Please upload the email from the applicant below and the attached revised drainage plans onto Ocella for BE/110/19/DOC for Salt Box.

Subject: RE: Saltbox - BE/110/19/DOC - Conditions 9 and 10
Importance: High

CLASS Z BEDDING
CONCRETE SURROUND

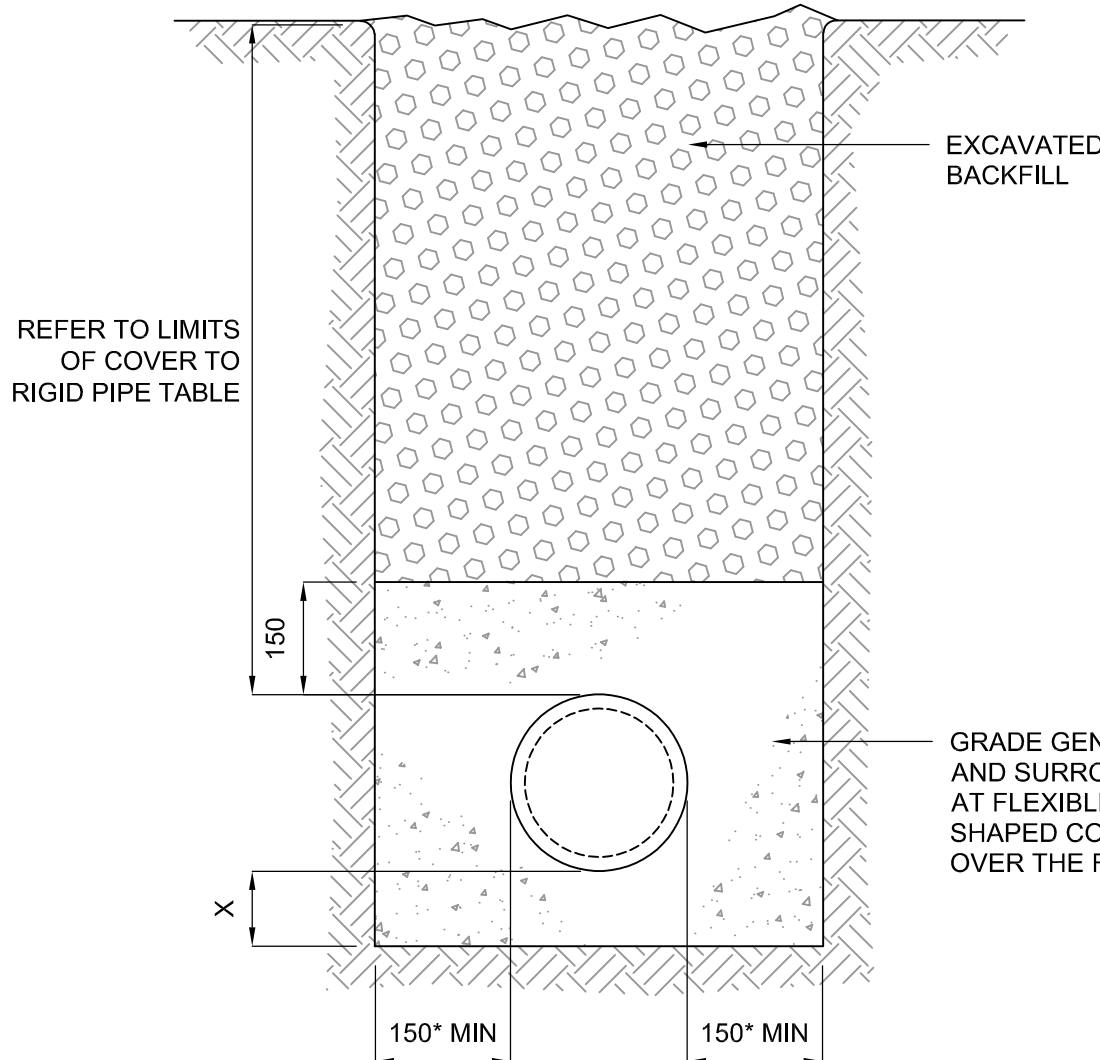
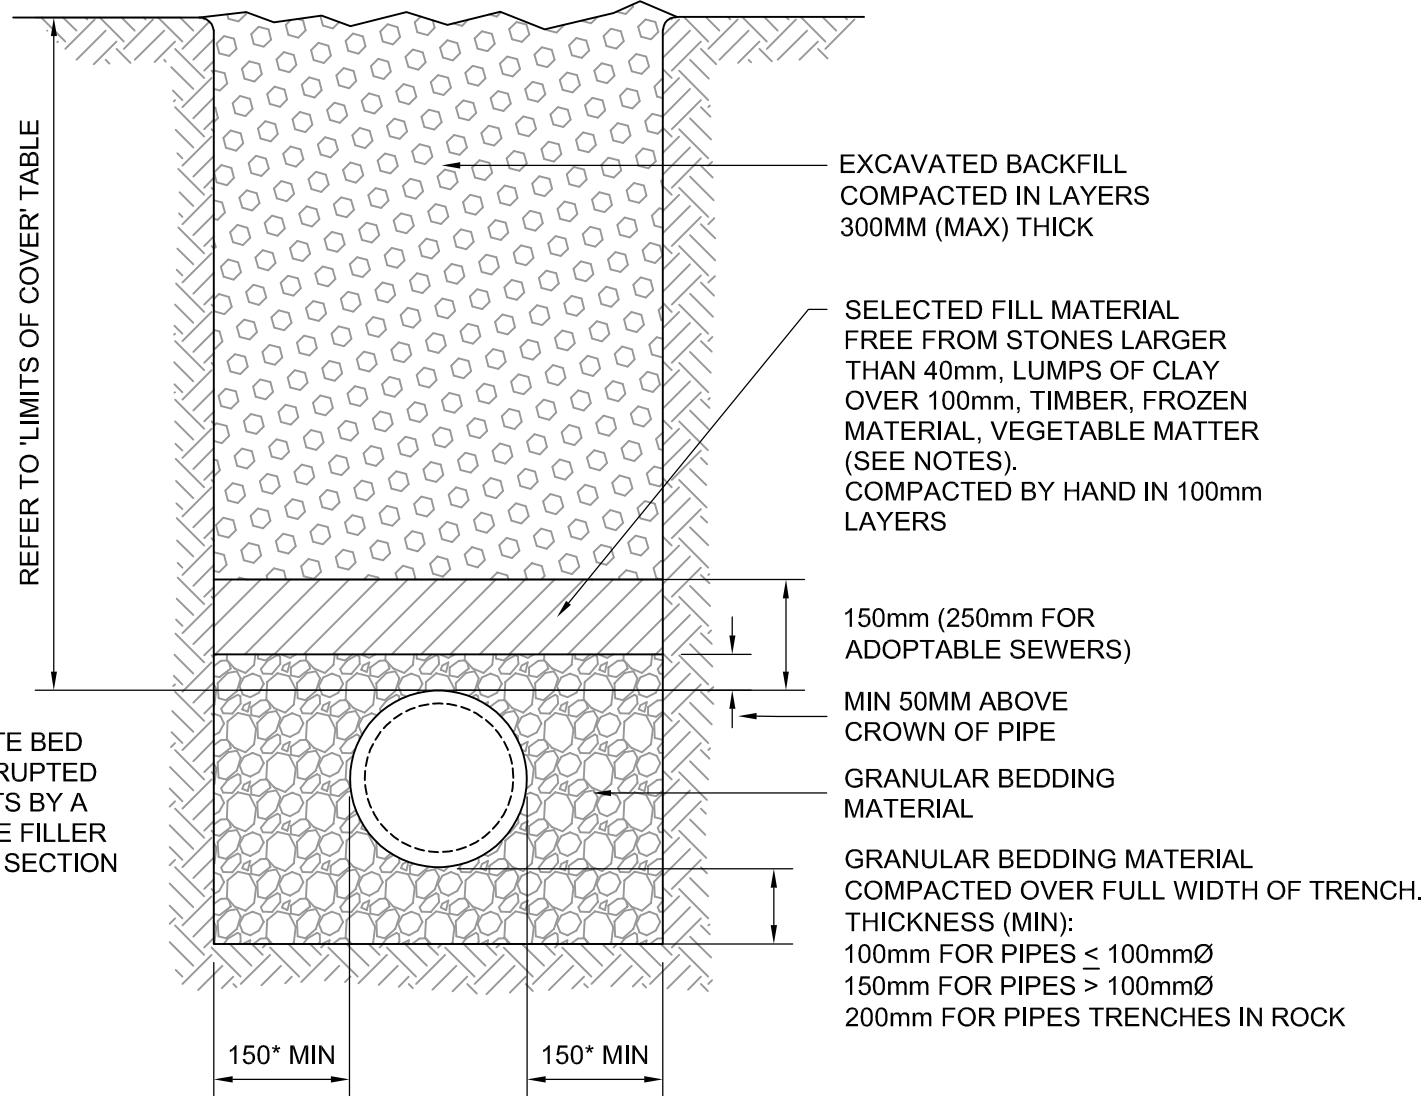
- D) Class S and Class Z bedding details still need to specify the min. 150mm (full surround) of shingle/concrete.

The bedding detail already notes the min 150mm surround but for clarity I have added a note and made the notes clearer (as clouded)

SAL-HYD-00-ZZ-DR-C-7010

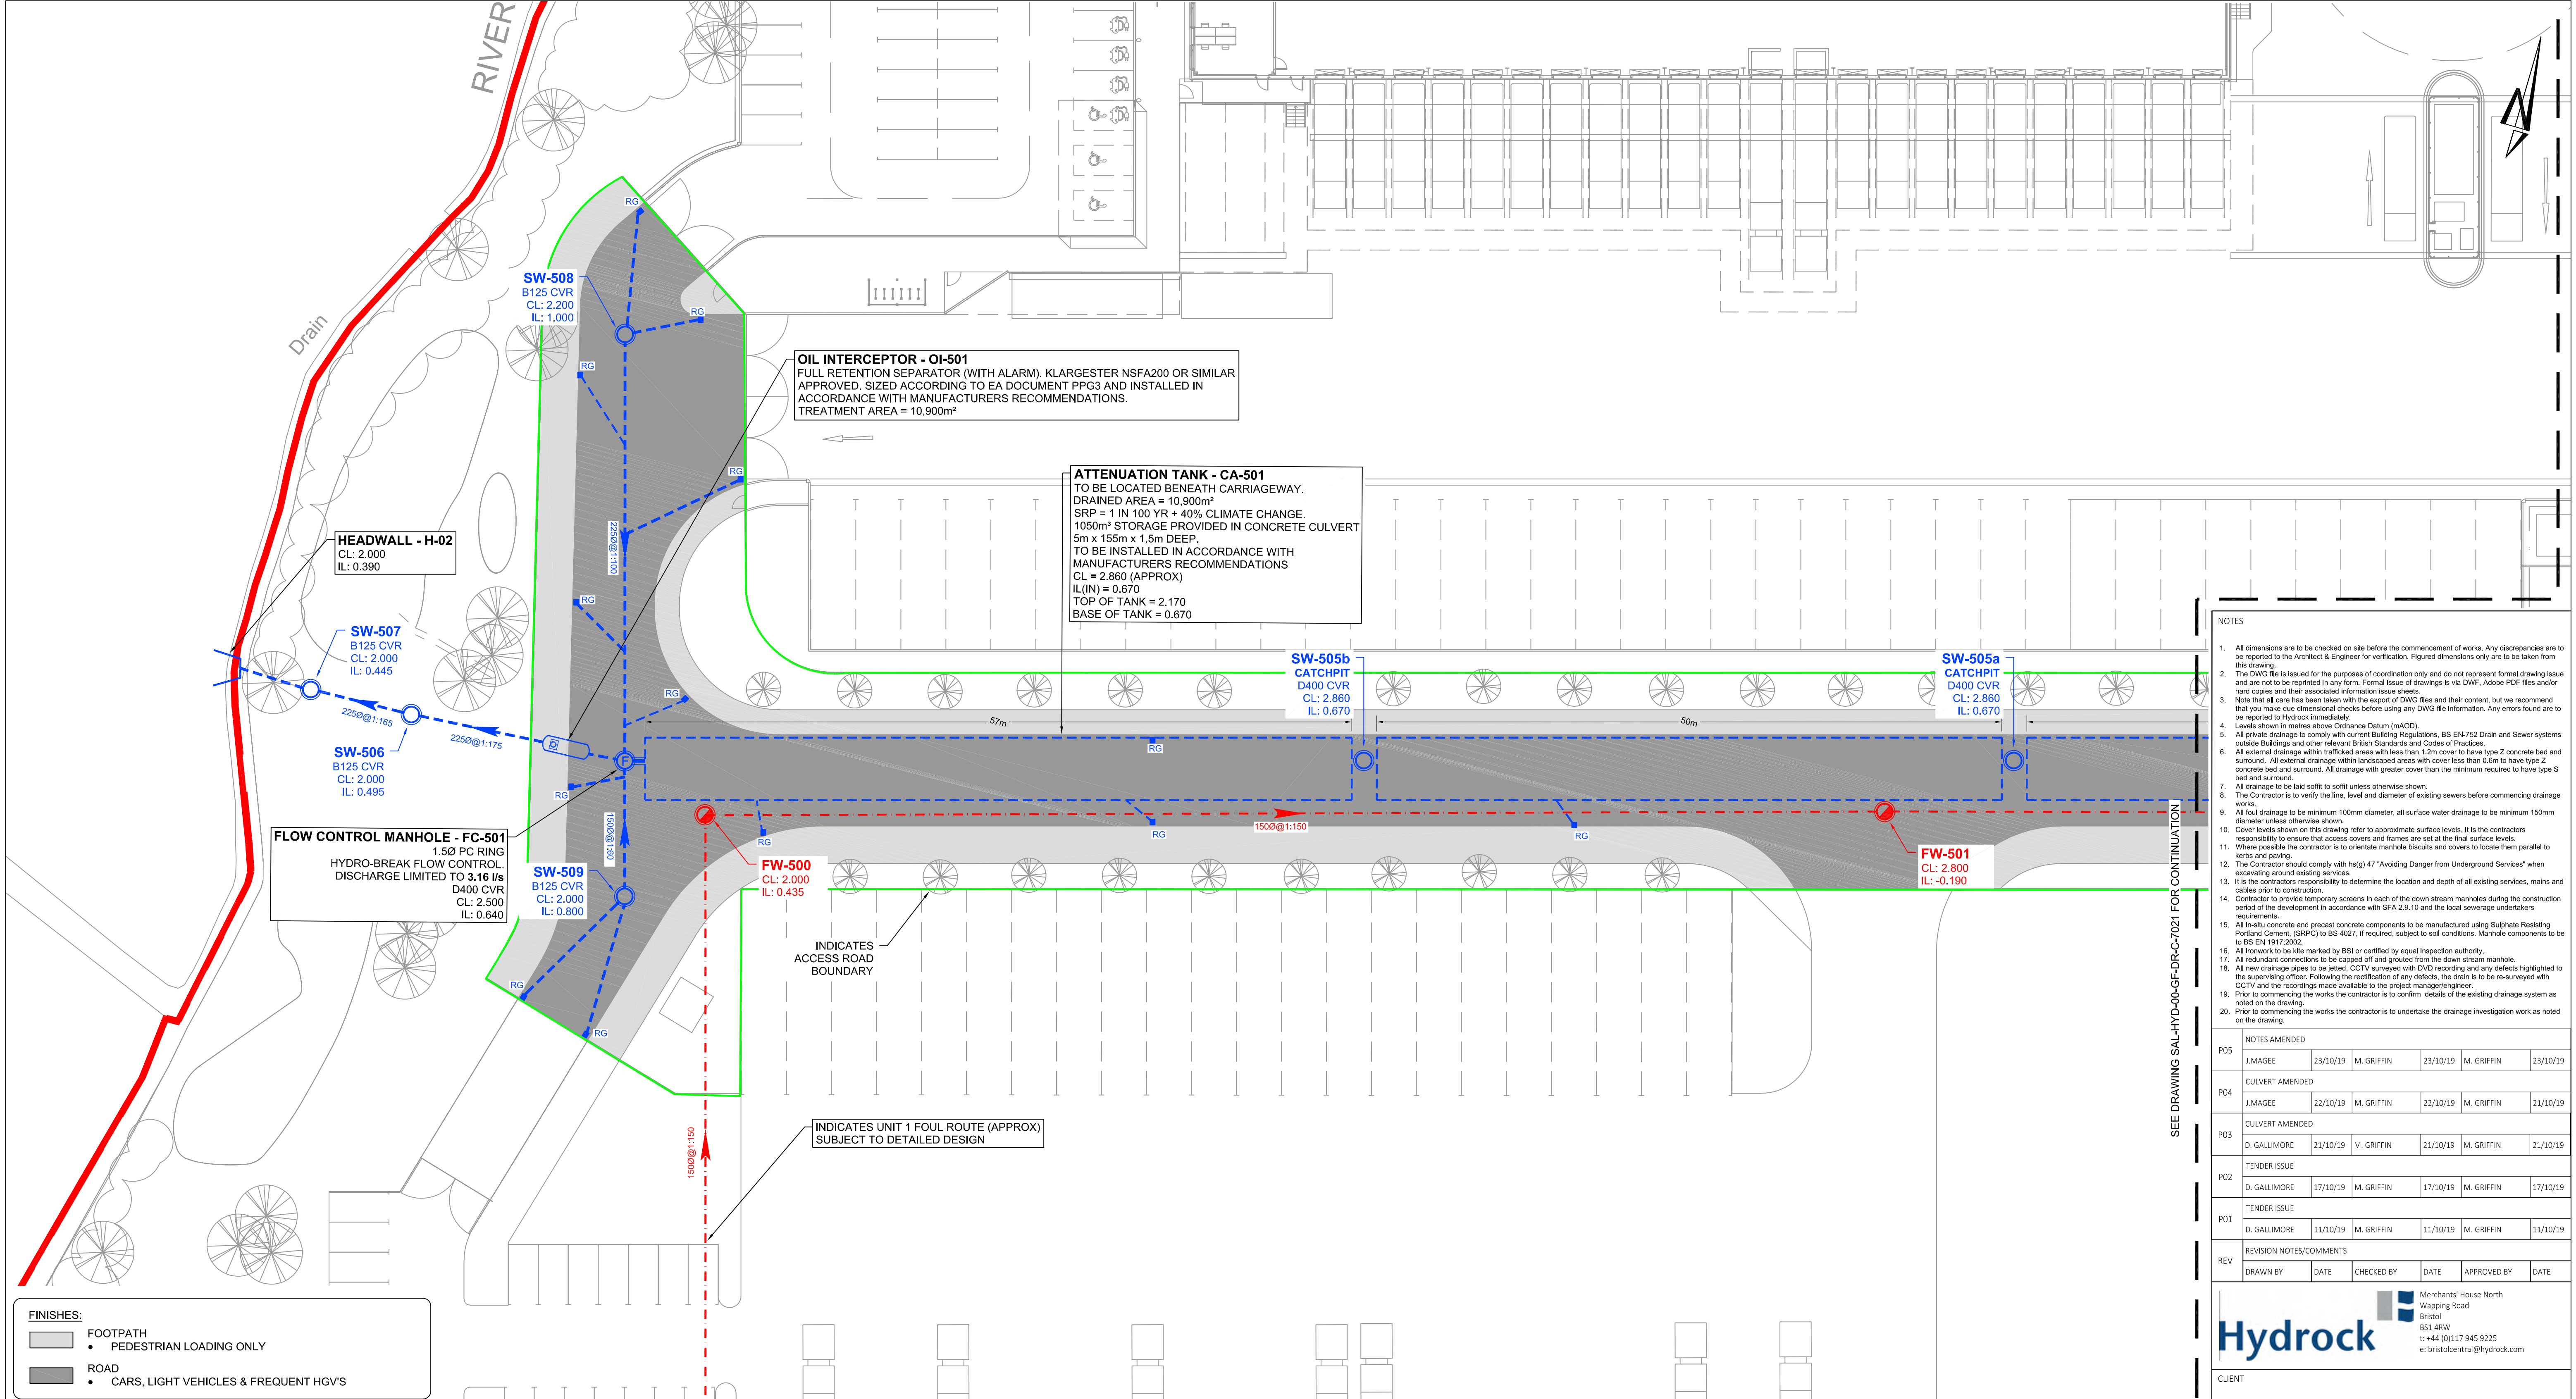
- A) MH SW-209 - Slight alteration required to ensure 225mm pipe connects to 450mm pipe at soffit to soffit level.

4. Whilst there has been improvement, we are still not achieving a soffit to soffit connection. Please investigate slackening the gradient between SW-201 and FC-201 in order to achieve this. We will look into this.

2. I don't see why the gradient cannot be improved to achieve the 1 m/s at full bore. This can be achieved by improving the gradient to 1 in 400 ie. an approx. 74mm additional fall, even if it means adjusting the steeper gradients upstream and downstream. Noted. Will amend to show 1:400 gradient. Drawing 7010 revised

4. Whilst hydraulic calculations may be satisfactory, this is not good practice and could lead to operational issues. Why can't the gradient between SW-1104 and the headwall be slackened to lower the 450mm pipe? This will also aid item 2. Will review along with item 2. Drawing 7010 revised to improve connection level

Drawing 7010 Amended to show soffit to soffit connection

Item 4 = Drawing Amended - Noted I have slackened the pipes in Unit two and raised the FC to allow for a soffit to soffit connection (pipe and detail also amended on drawing 7103)

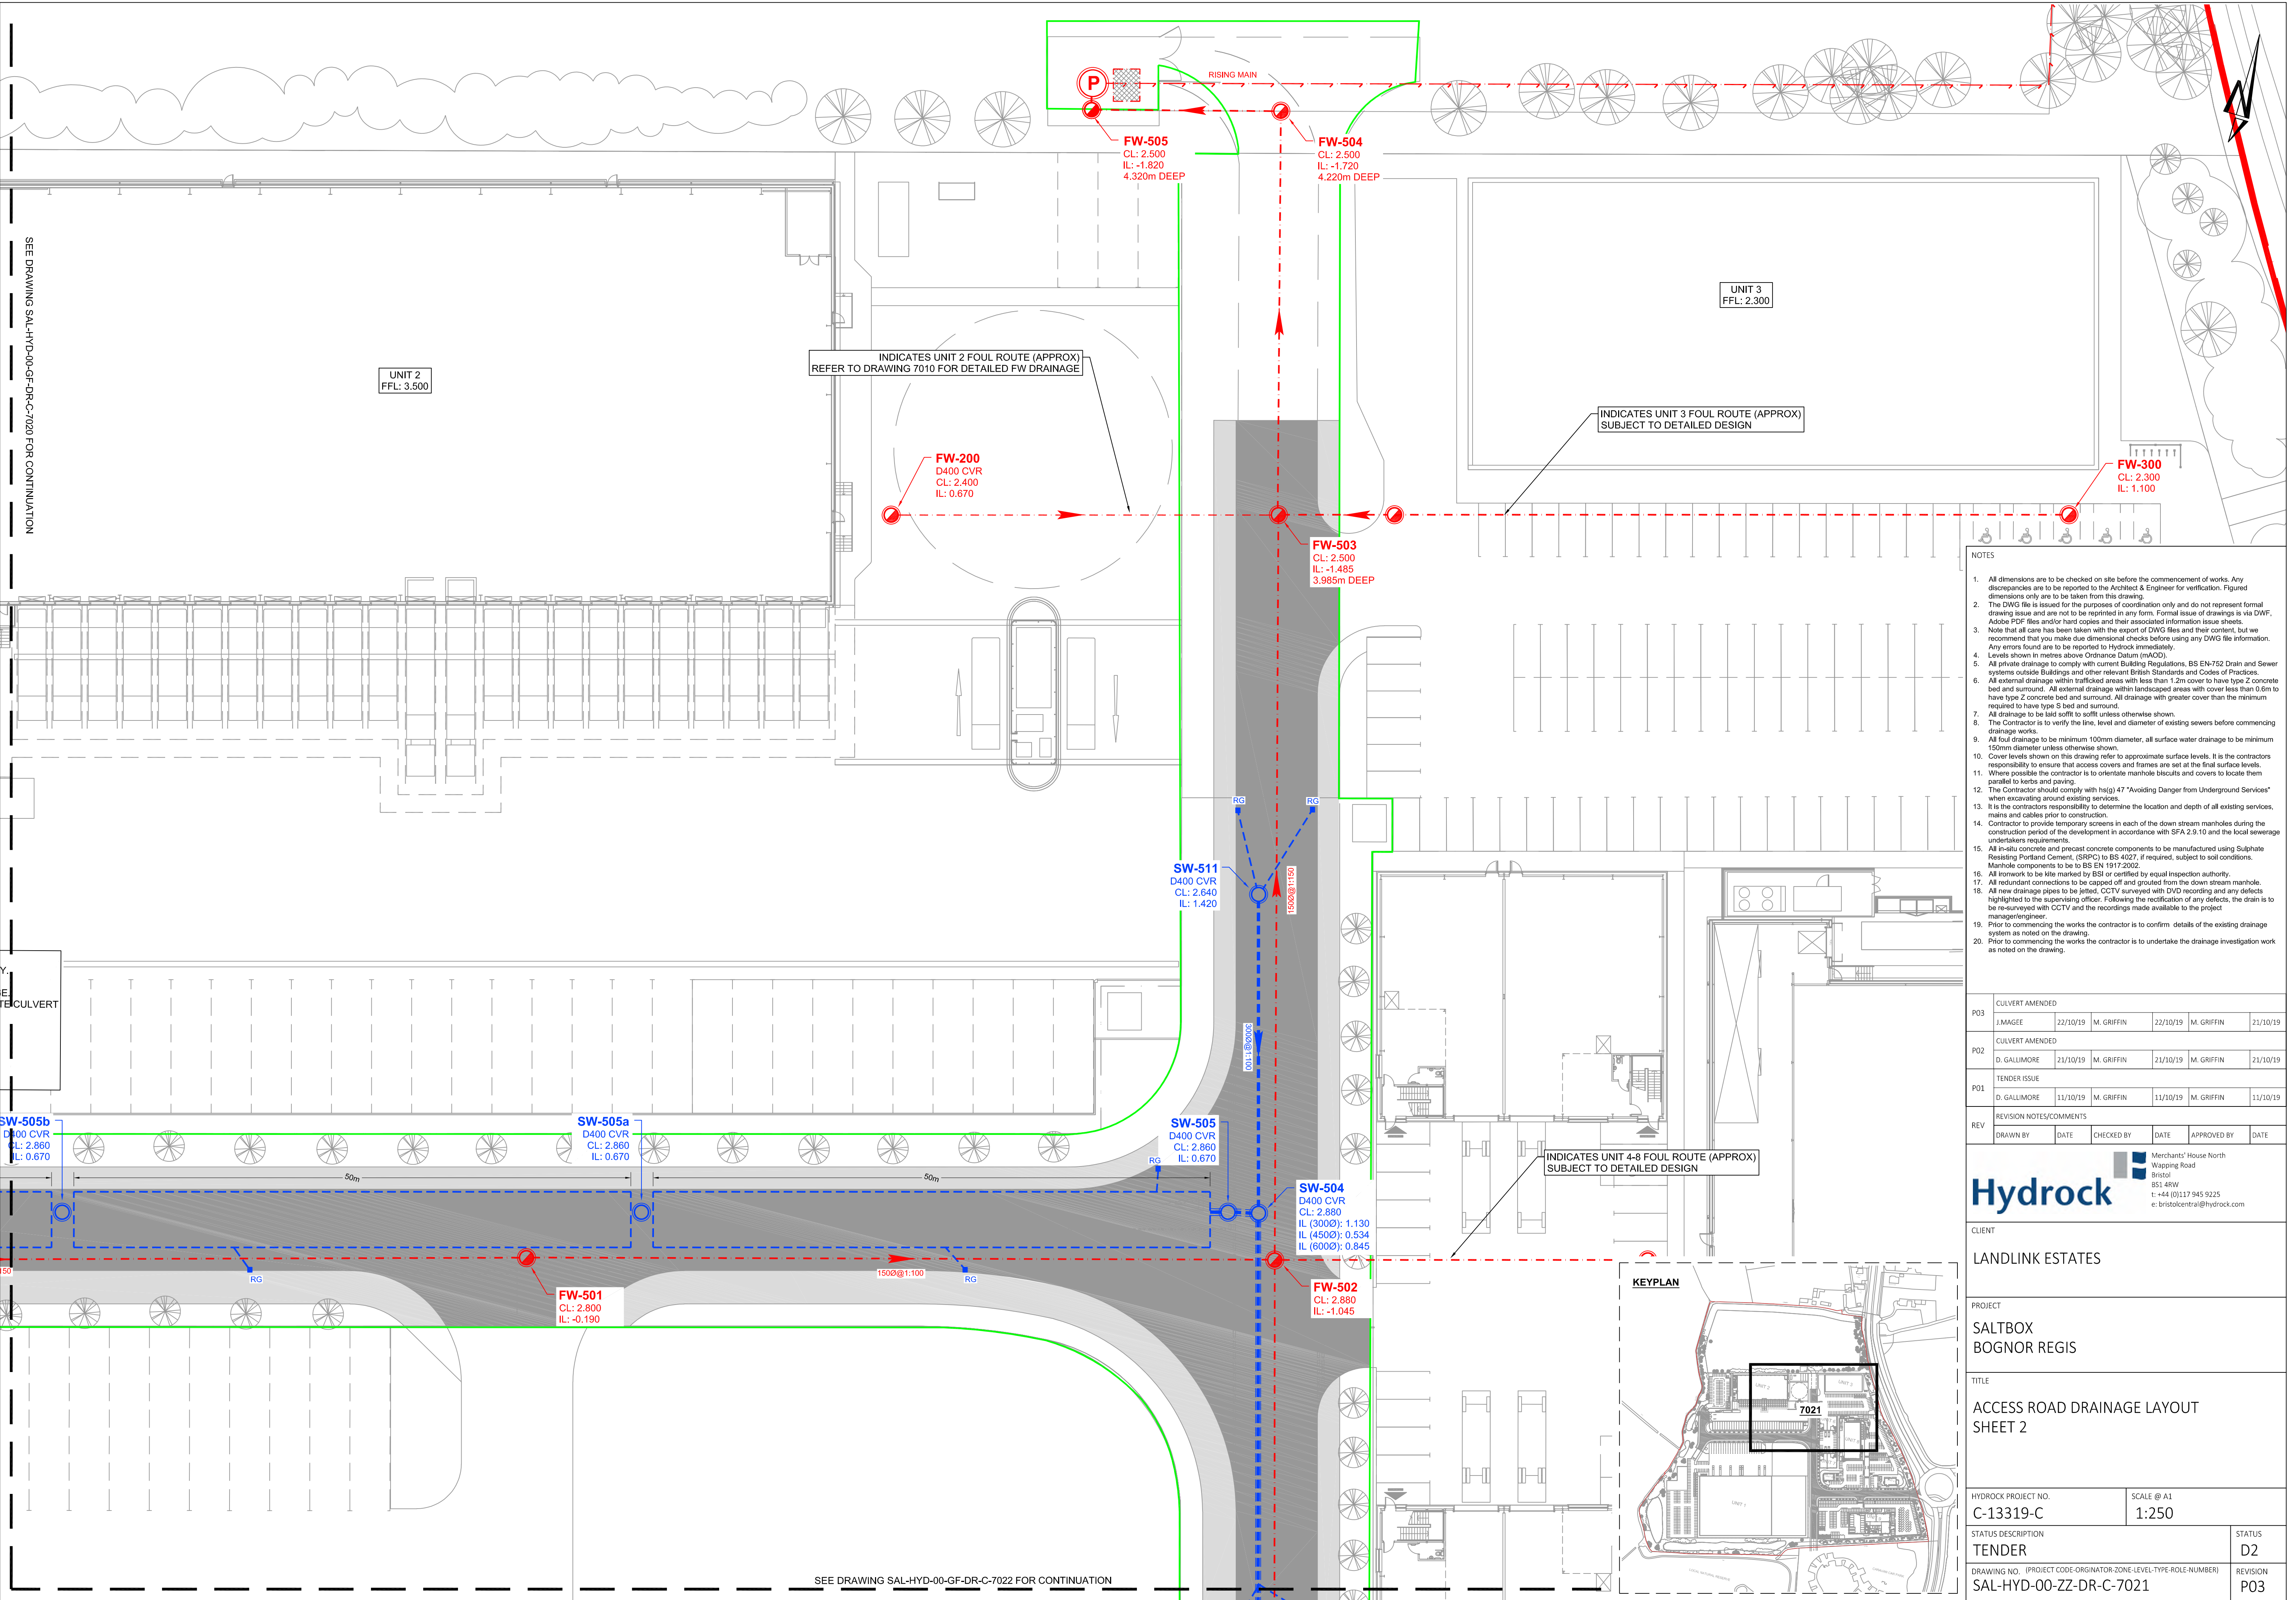
The layout plan 7020 key specifies 1.2m dia catchpits but some will be larger diameter due to the larger diameter pipes being incorporated. For example, the catchpits associated with tanks should be 1.5m dia. Please adjust as necessary. Drainage legend note amended on drawing 7020
